Case Ref. : ABP-322204-25

RE: Application under s.177E of the Planning and Development Act 2000 (as amended) for Substitute Consent relating to peat extraction on lands within Derryadd, Derryaroge and Bannow Bog, Co. Longford.

Derryadd, Derryaroge, & Lough
Bannow Bogs – Application for
Substitute Consent

Response to Request for
Information

SETTLEMENT POND
STANDARD DETAIL

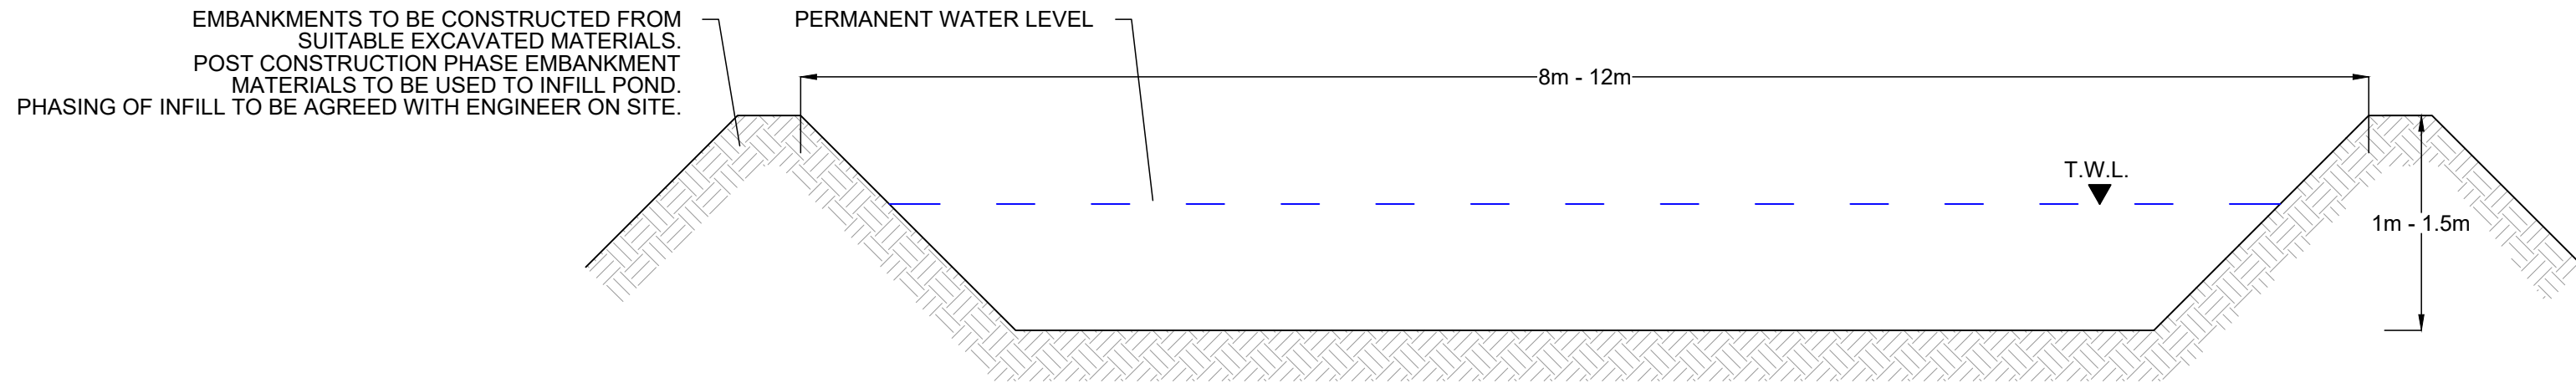
The drawings submitted do not appear to indicate (i) the location of, or (b) provide details (i.e. elevations) of ancillary infrastructure referred to in the development description contained in the public notes, for example fuel tanks.

Details on settlement ponds, including cross-sections, are available as Dwg. No. 11400-2010 of the planning drawing pack submitted as Appendix 4.19 of the rEIAR.
